Recommendation Report for Planning Permission for Works or Extension to a Dwelling

REF NO: AL/88/19/HH

LOCATION: 9 Lidsey Road
Woodgate
PO20 3SU

PROPOSAL: Single storey rear extension

sheet 2 of 3

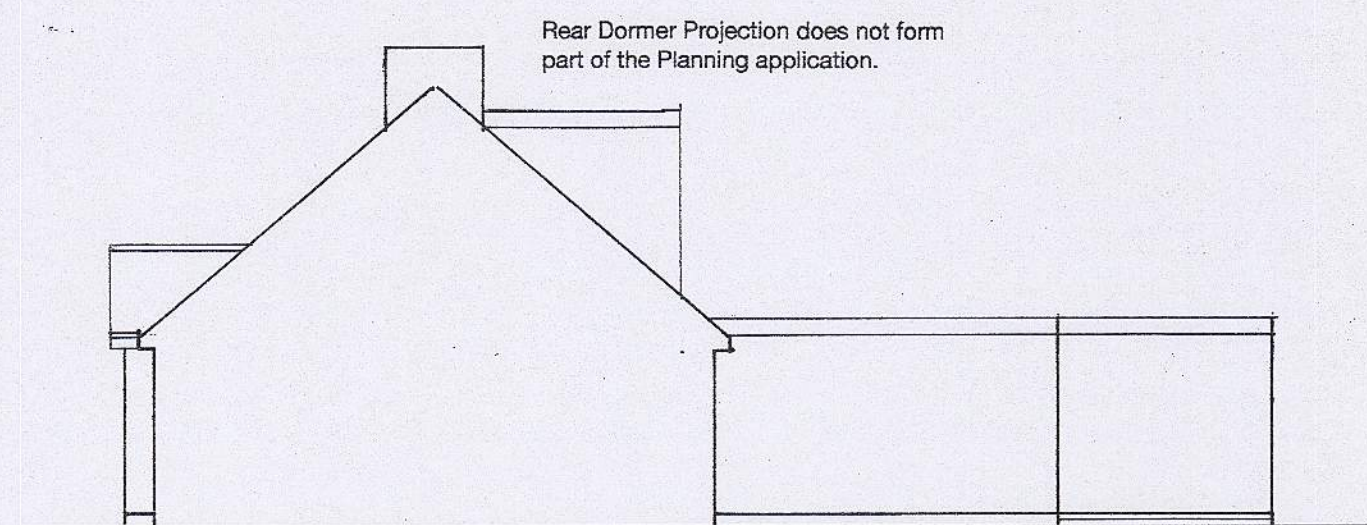
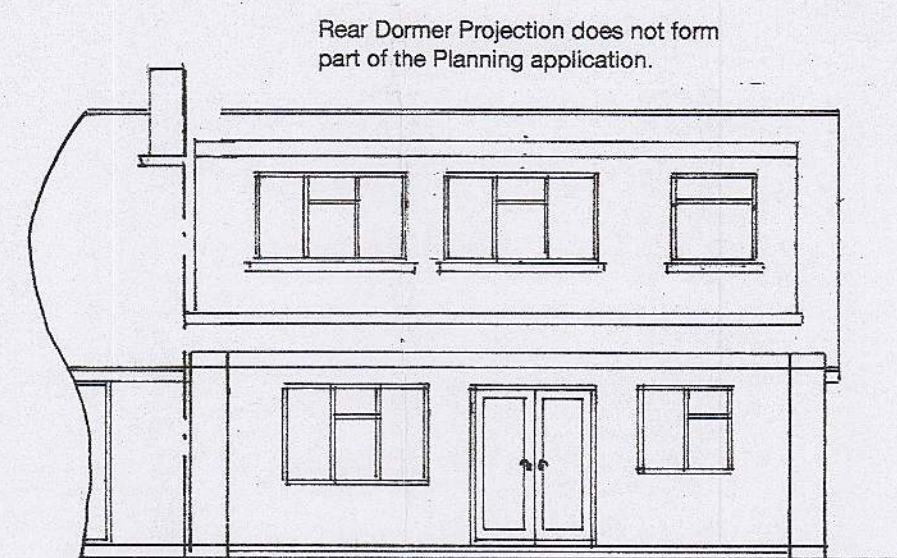
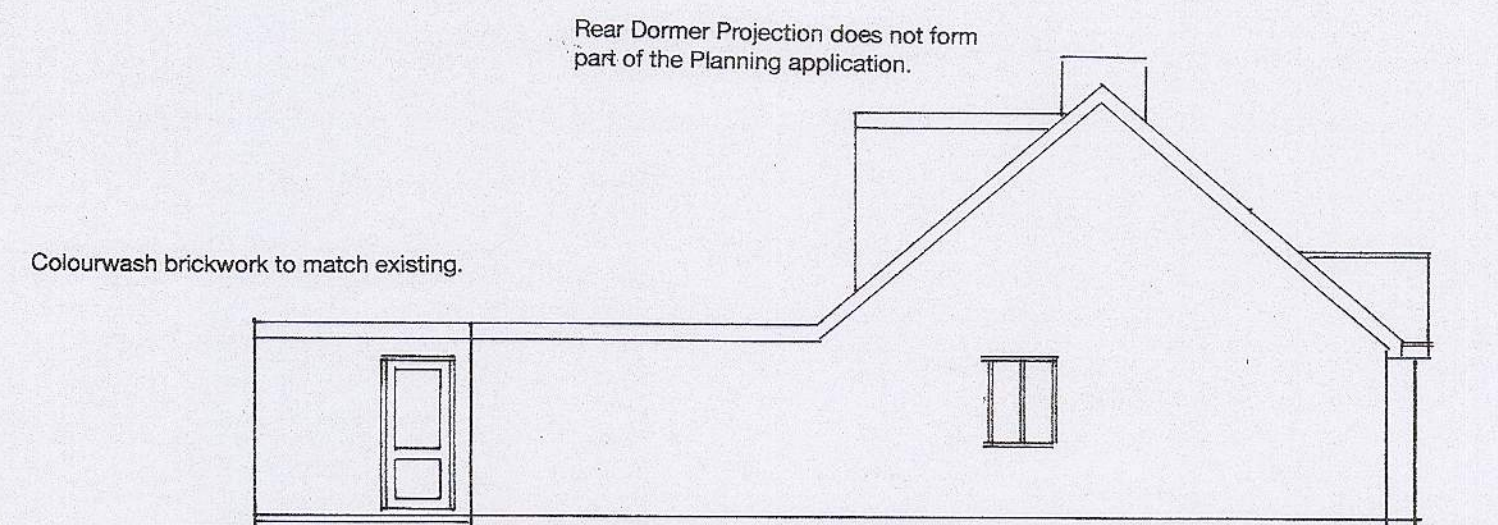
The extension will not be visible from the street scene as a result of its siting to the rear of the dwelling. The rear extension will have a maximum height of 2.5m and as a result does not appear unduly dominant. The development appears well integrated with the host dwelling as a result of its size, design and materials being used that match the existing.

sheet 1 a of 3

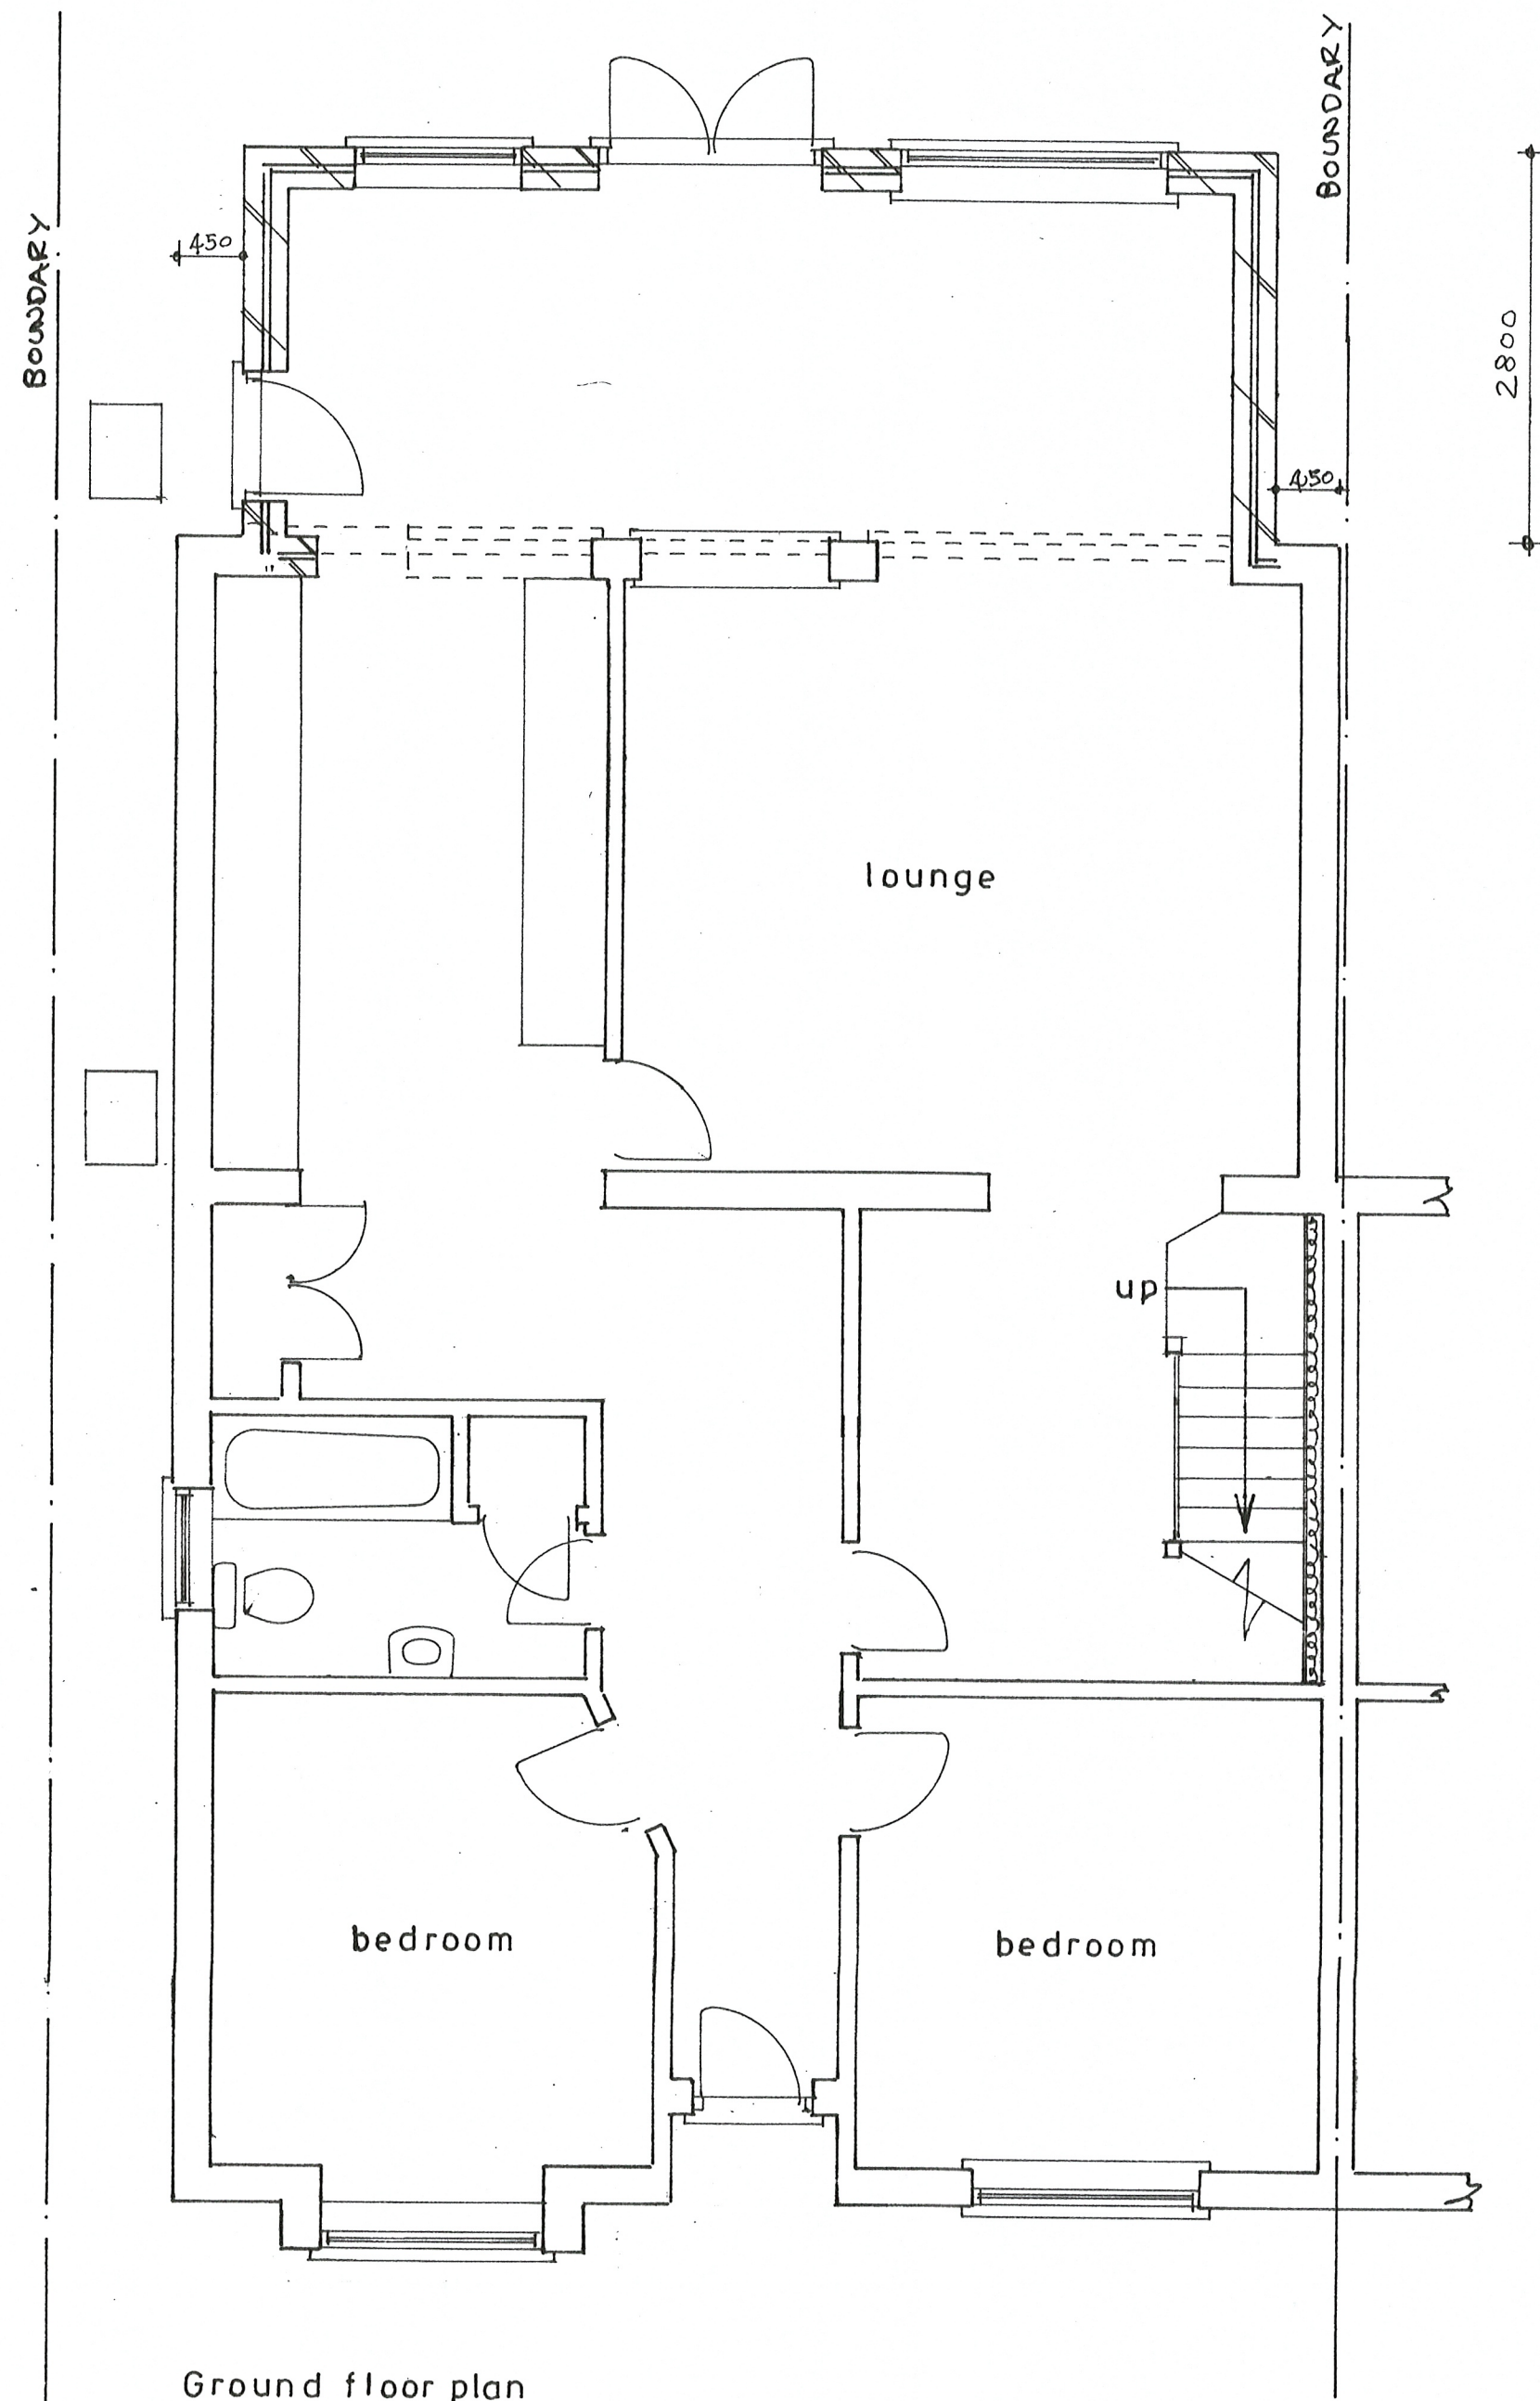
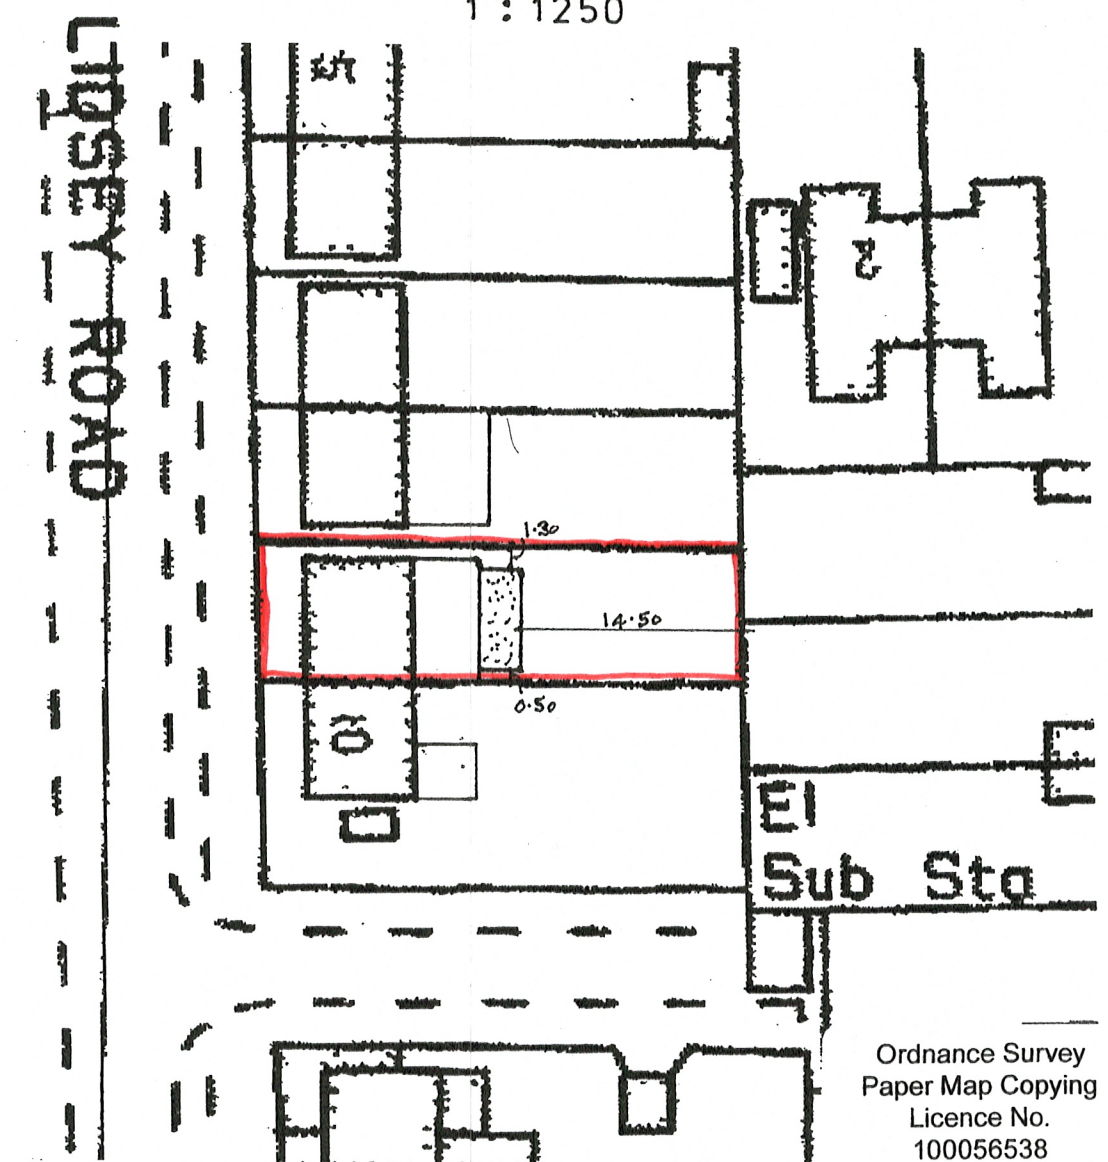
The development will run the width of the rear elevation and extend the property by 2.8m. There is a 1.3m gap between the proposed extension and the boundary to the north. The neighbouring property has an extension to the rear of a similar length. Whilst the proposal is closer at only 0.5m to the southern boundary it is not considered to give rise to any unacceptable over bearing or have a detrimental impact through breaking the 45 degree rule due to the existing extension and the height of the proposal. There is a proposed pair of doors to the rear extension facing east looking down their garden leaving 14.5m to the rear boundary and as such is not considered to give rise to any adverse overlooking upon neighbouring amenity.

It is acknowledged that the neighbouring property to the north has an extension and this would protrude past it, however, it is not considered to be overbearing due to the flat roofed nature of the extension. It is also not considered to have an unacceptable level of overshadowing. As a result of the modest scale and design the proposed development is not considered to harm neighbouring amenity by way of overbearing, overshadowing or overlooking and accord with DDM1 and DDM4 of the Arun Local Plan.
